REPORT UPDATE

Application No: LU/231/17/PL

REF NO: LU/231/17/PL

LOCATION: Castleview Nursery
Old Mead Road
Littlehampton

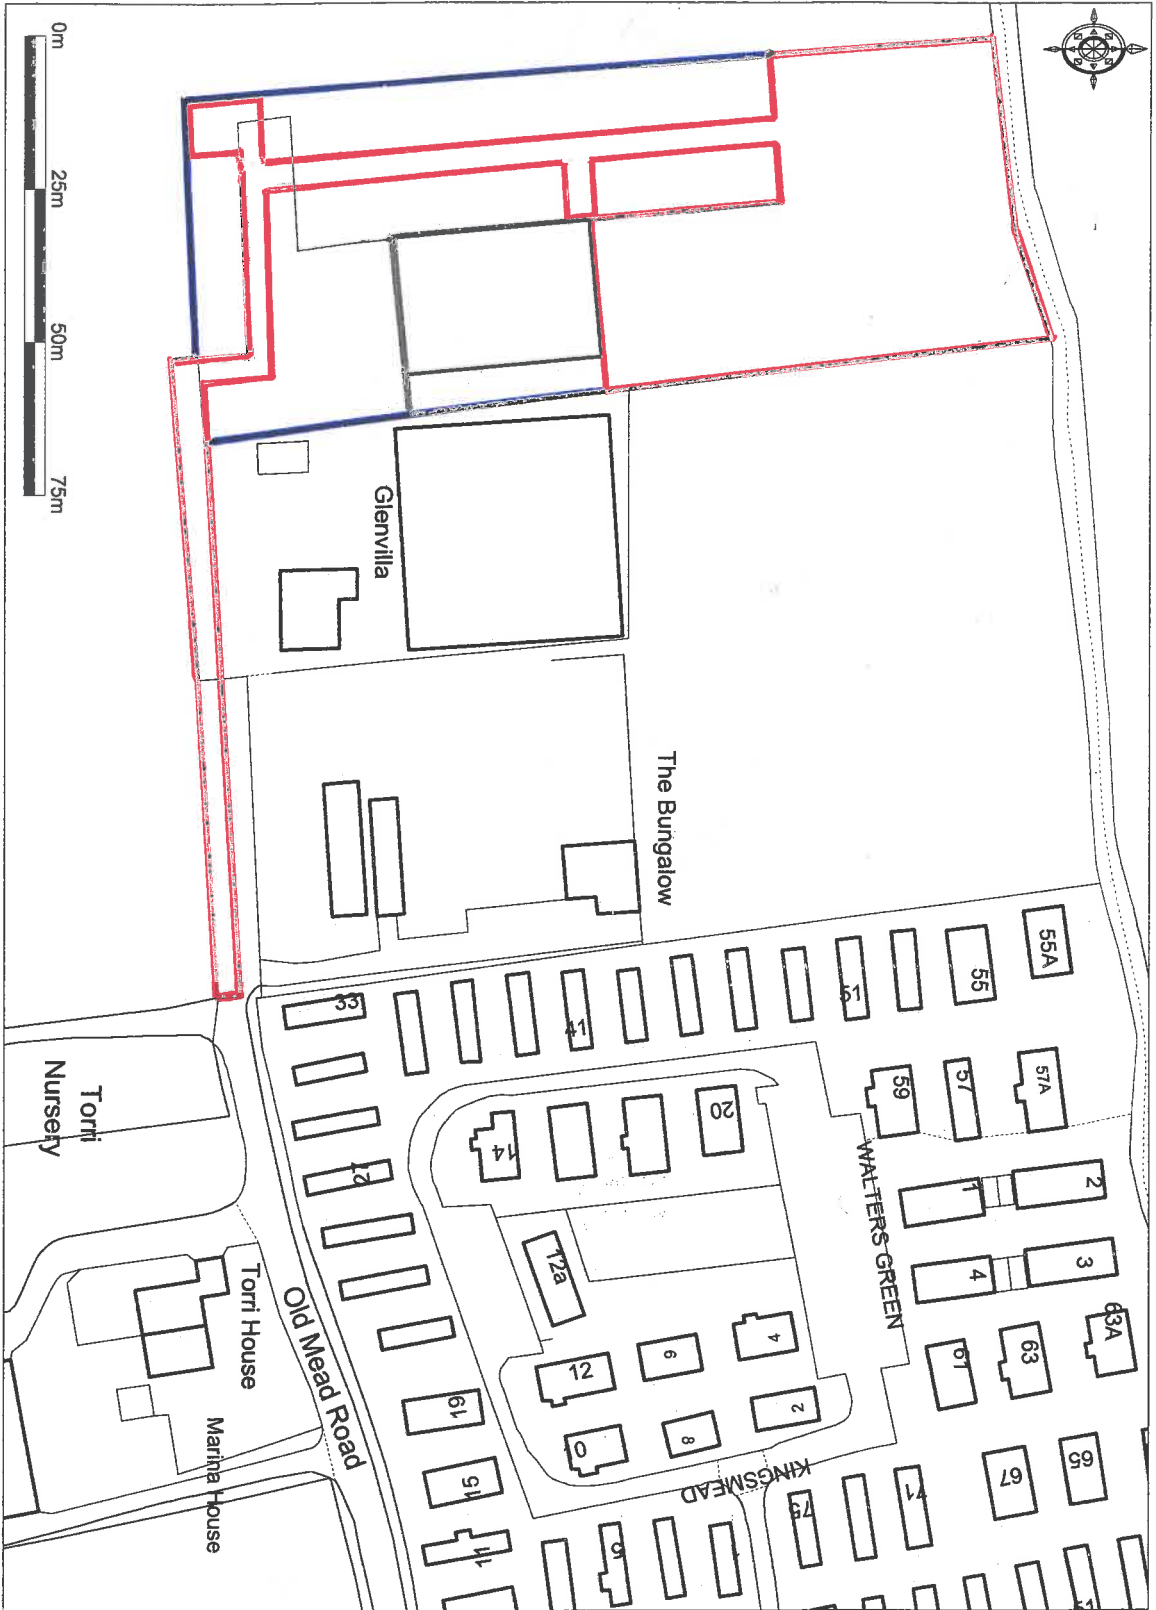
Page 46 - O.S. extract - west boundary of plan not as per submitted site plan
